## A303 Sparkford to Ilchester Dualling Scheme TR010036

### 8.4 Statement of Common Ground with Somerset County Council and South Somerset District Council

**STATEMENT OF COMMON GROUND**

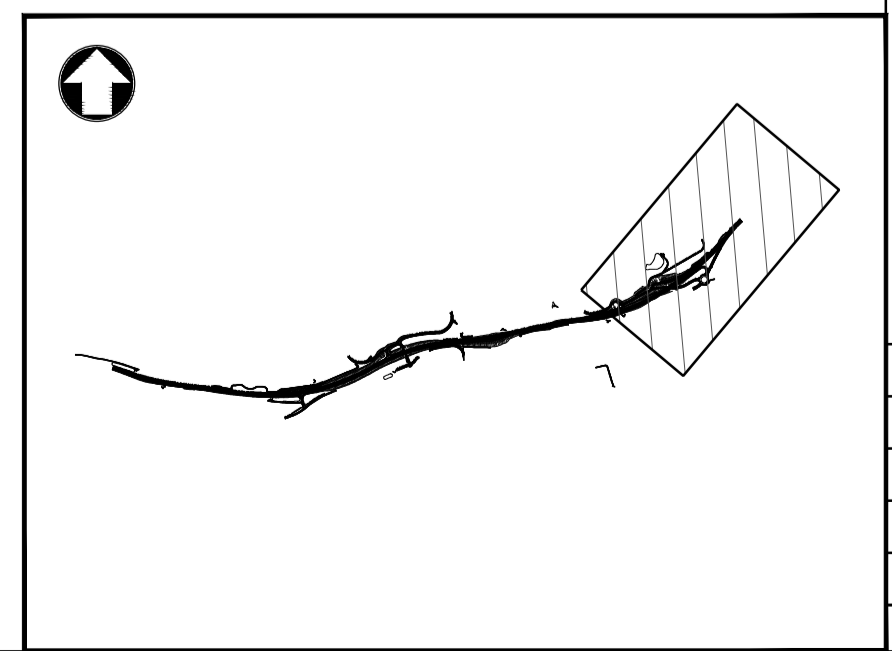
Lighting	Responsibility for proposed system of lighting at Hazlegrove Roundabout is yet to be resolved, although SCC's view at this time is that Highways England would retain maintenance responsibility.	Noted, although this is a detailed design point and so the Applicant is not in a position to agree this at stage.	<b>NOT AGREED</b>
Drainage	Detailed drainage proposals confirming that only surface water runoff from the local highway network discharges to Pond 4 will need to be submitted before SCC are able to accept maintenance responsibility for this pond.	Noted.	<b>AGREED</b>
